Latigo Winery, LLC

November 12, 2019

9.77 acres, RR-5
Schedule No: 5219000032
N2S2NE4NE4 EX RD SEC 19-12-65

Letter of Intent

SITE PLAN

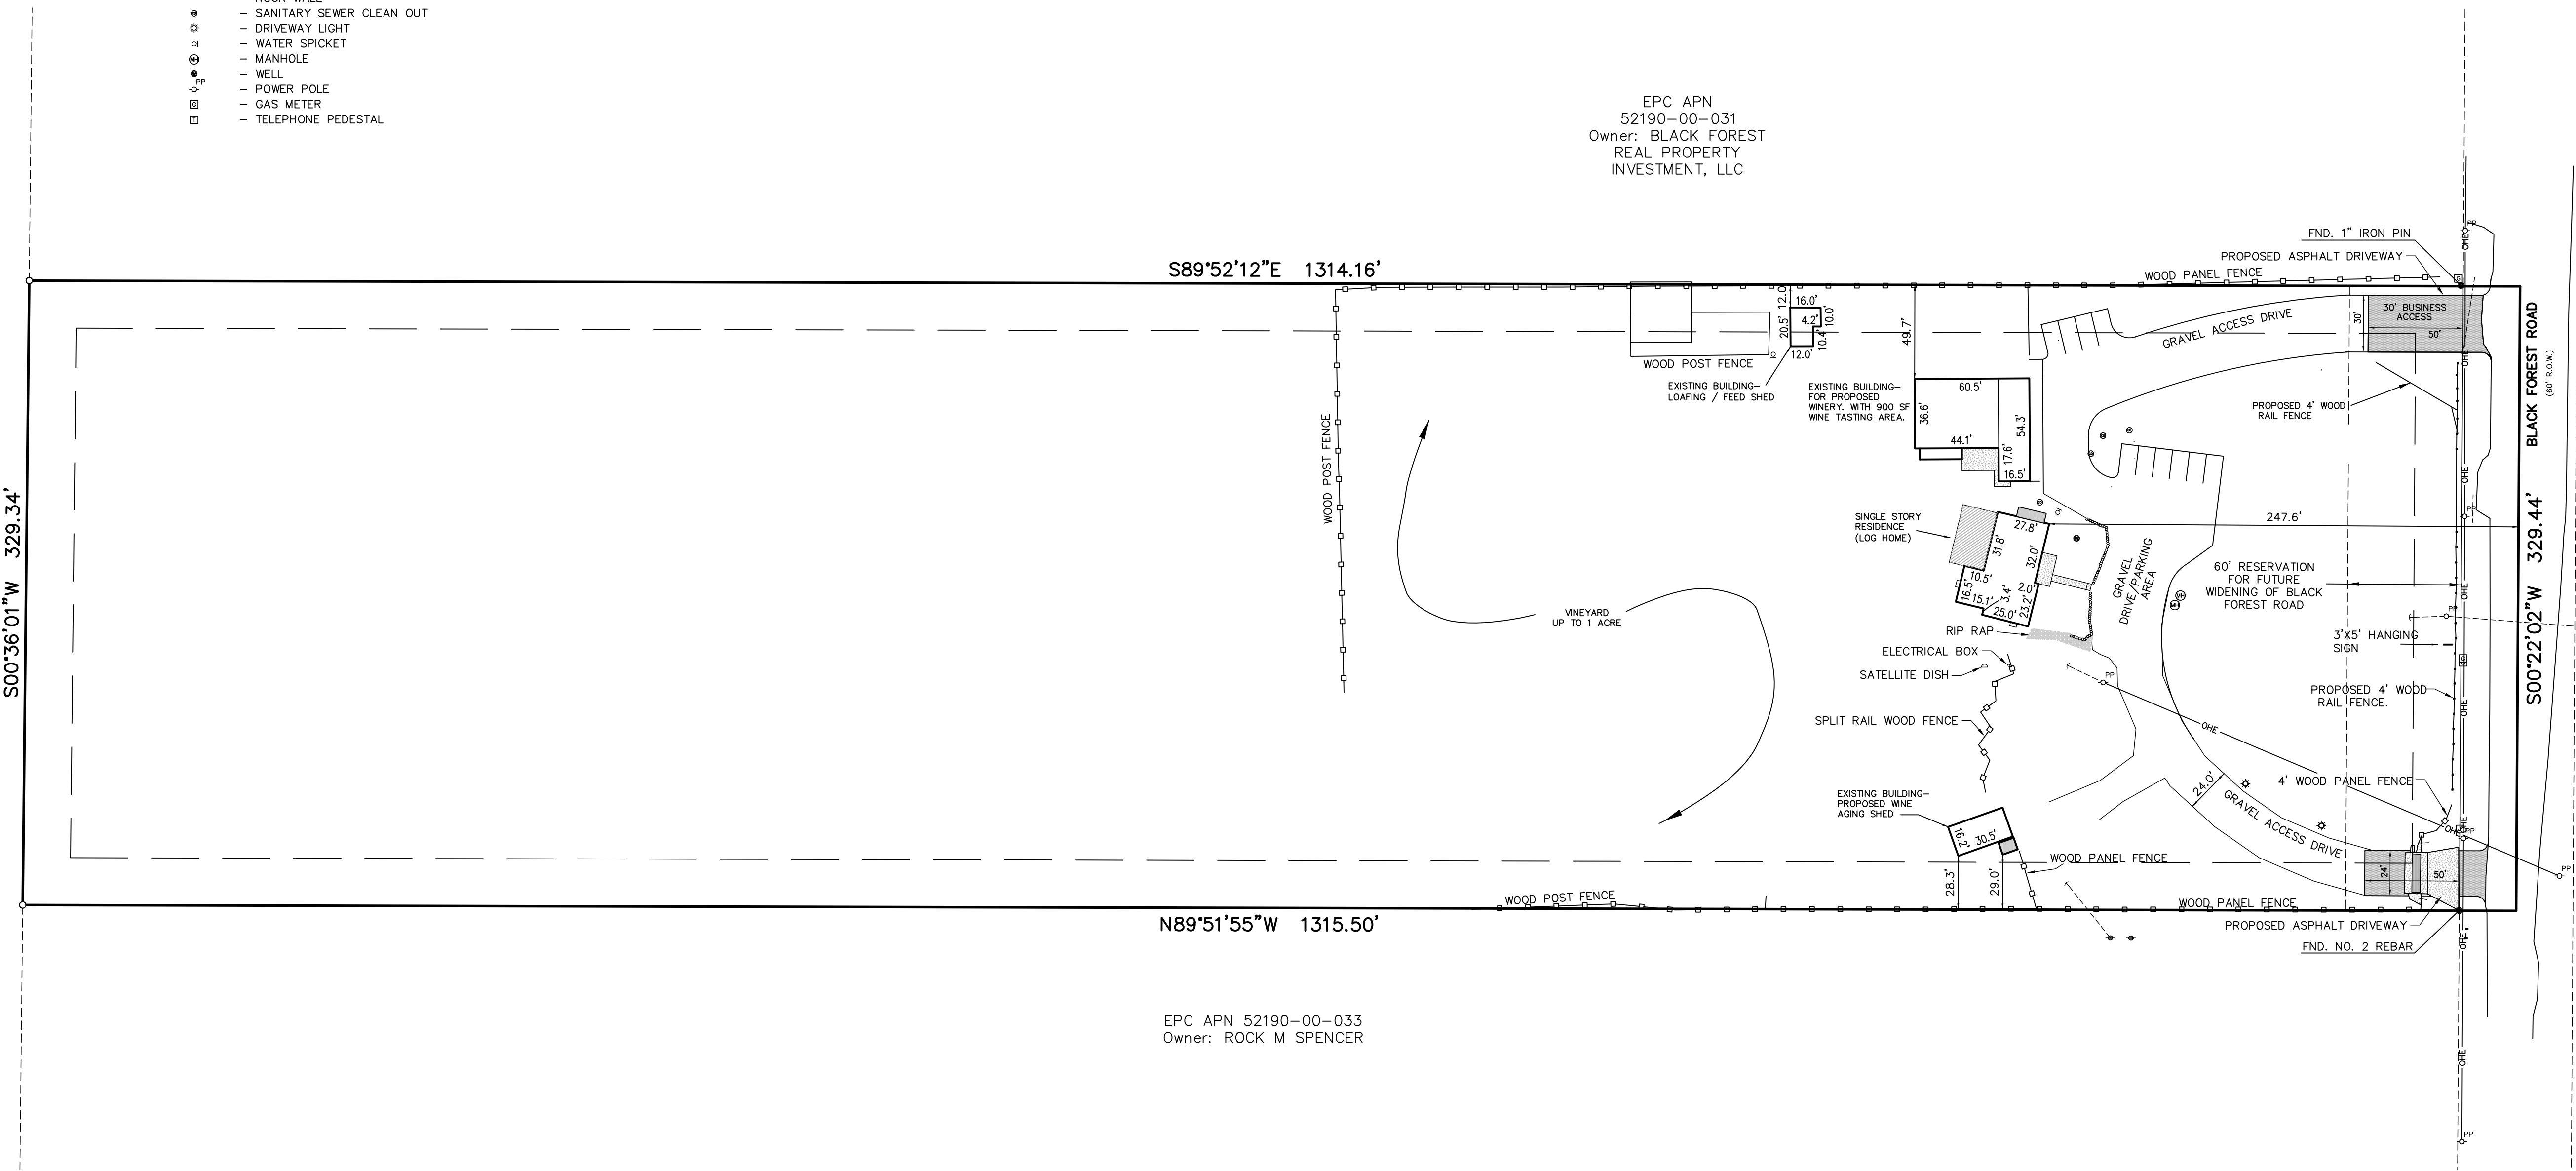
How: Detail what building will be used to what use. Will the production, bottling, aging take place on the property... etc. Provide maximum number of employees with consideration of future growth. Detail maximum number of daily traffic expected.
